RFI

RFI #: 7
Date: 12/1/2011
Job: EB-02 Keller Springs Lofts
Phone: 877-777-5115

Subject: RFI# 7 pool fence height

Subject: 12" paver bands in courtyards

SHEET
5C OF 9

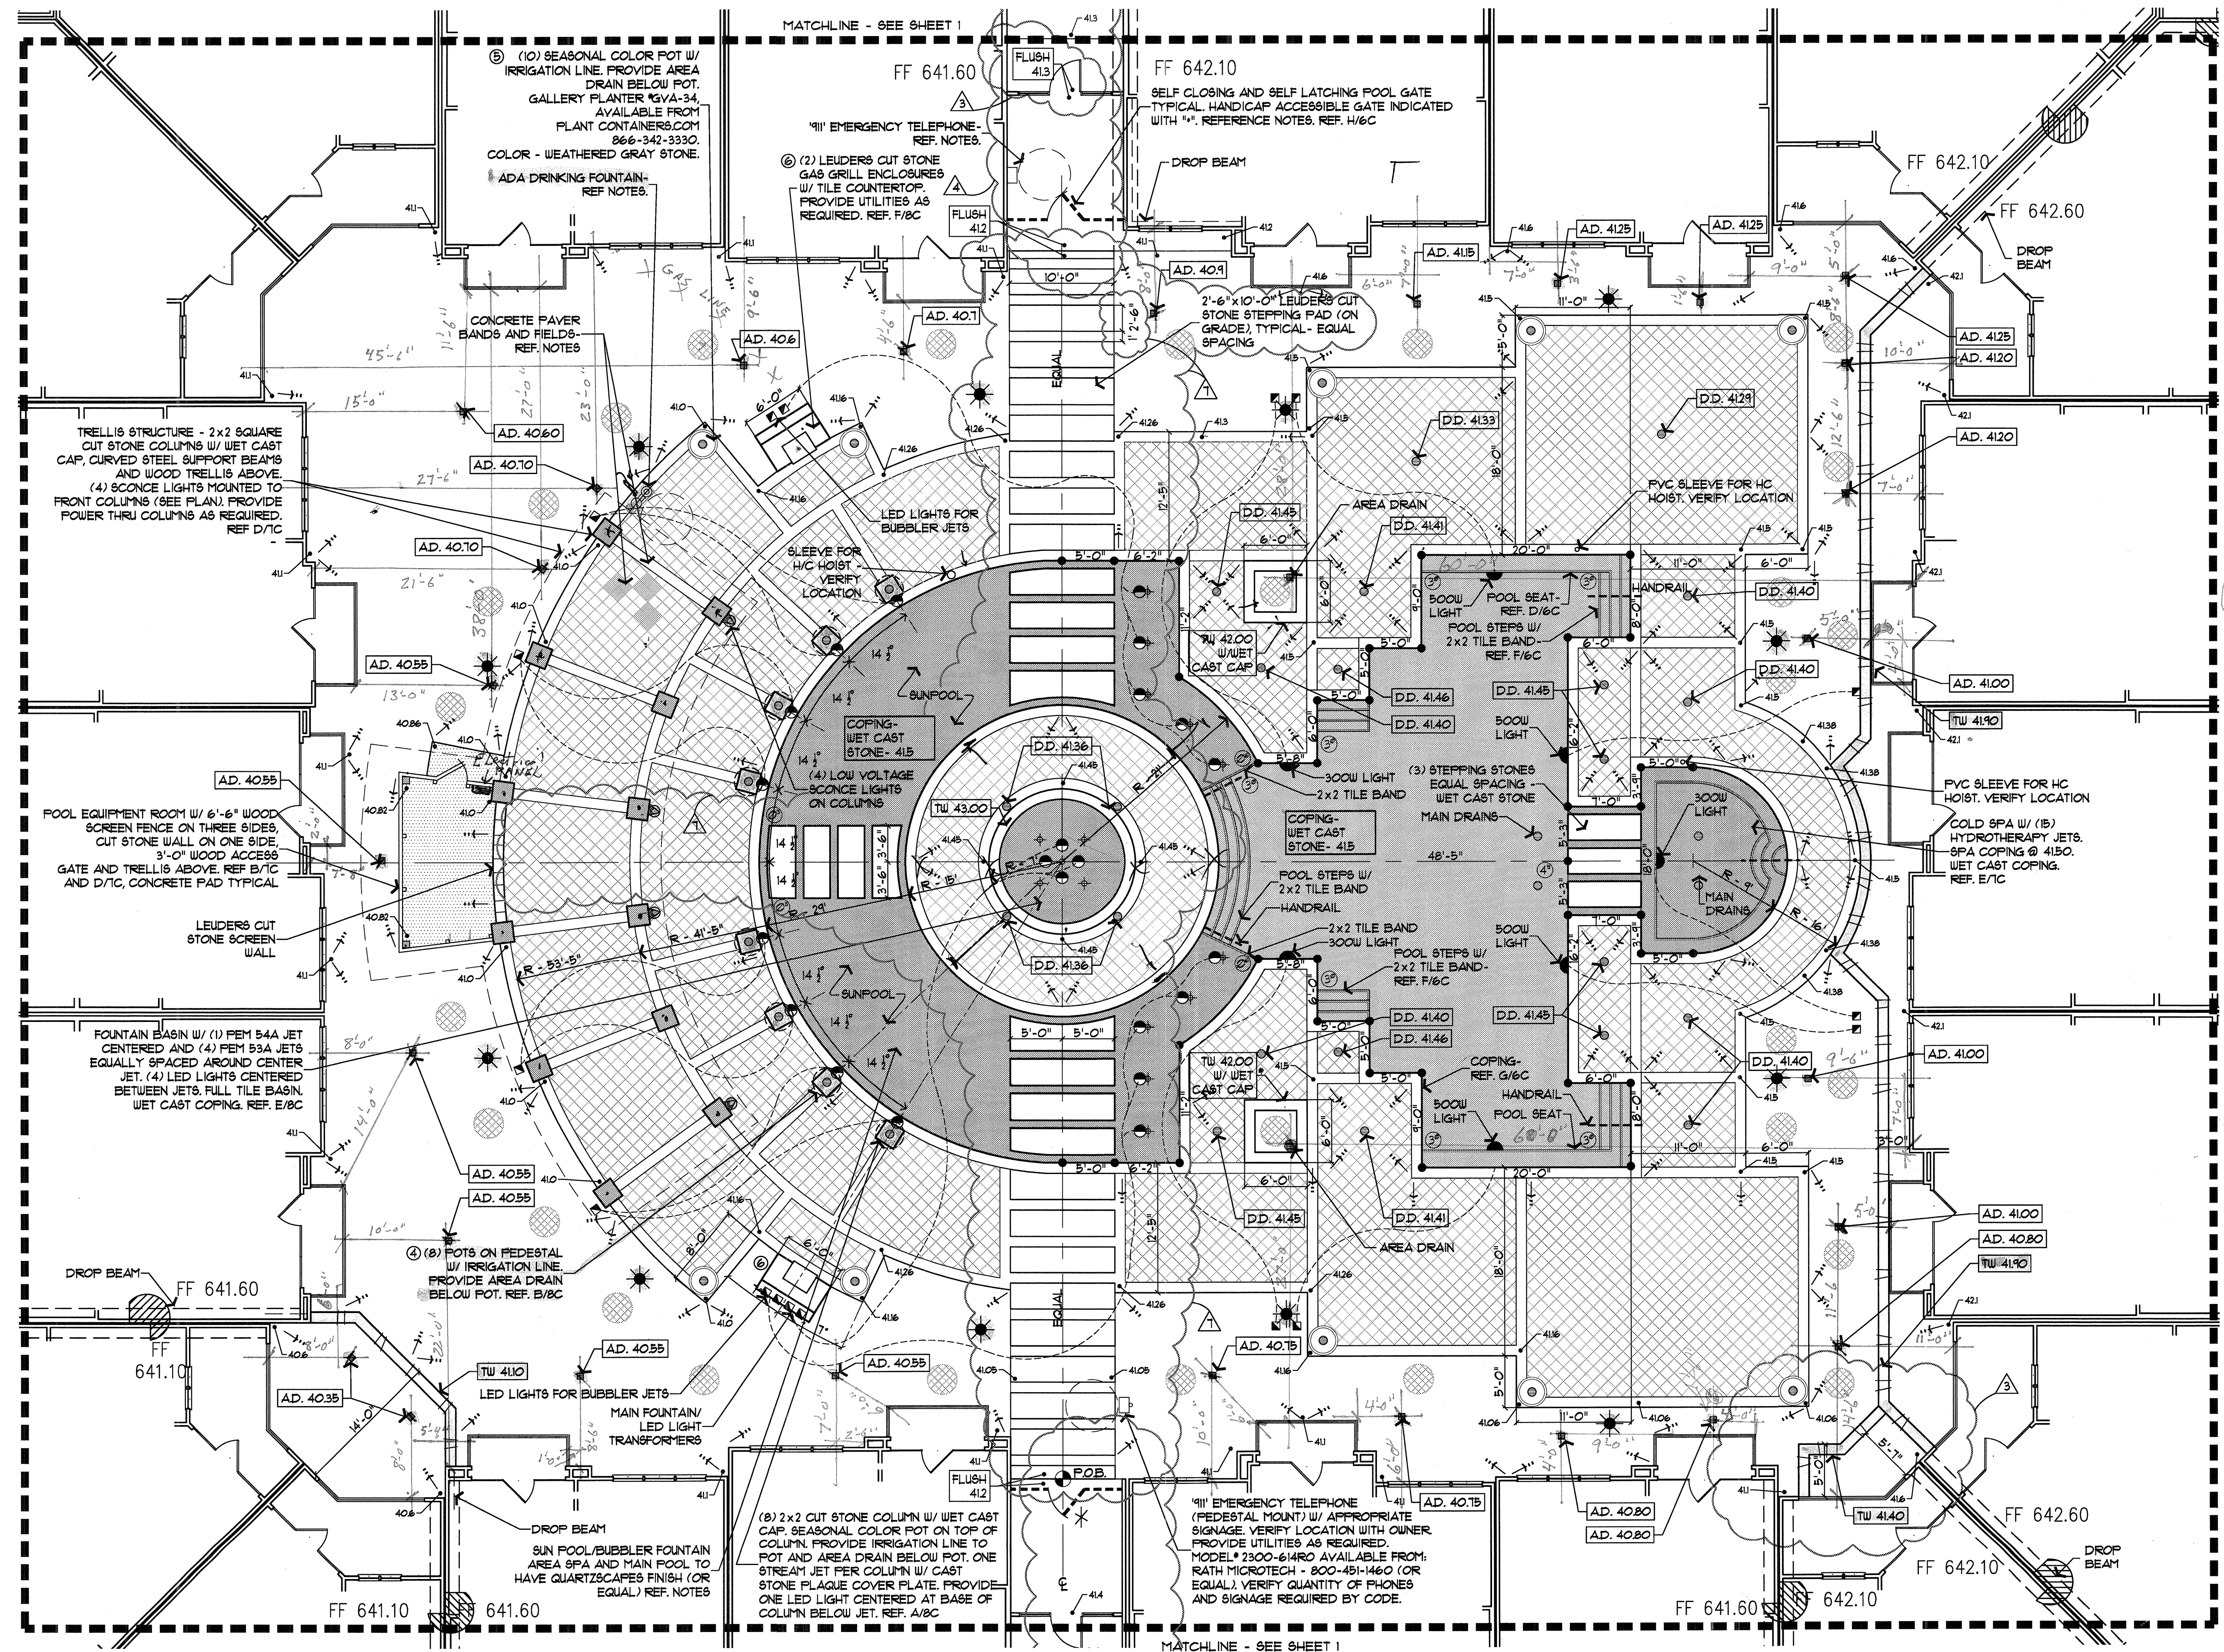
Request: For clarification what is the pool fence height? **Date Required:** 12/8/2011

Response: Per Detail H/6C pool fence height is 4' 3"

Request: THE POOL SUBCONTRACTOR NEEDS TO KNOW IF THE 12" BANDS ARE SINGLE PAVERS 12" X 12" OR ARE THE 4" X 8" IN 12" PATTERNS PLEASE ADVISE. **Date Required:** 12/19/2012

Response: the 12" paver bands in the courtyards are city stone III (12x12) single pavers in a stacked bond layout.
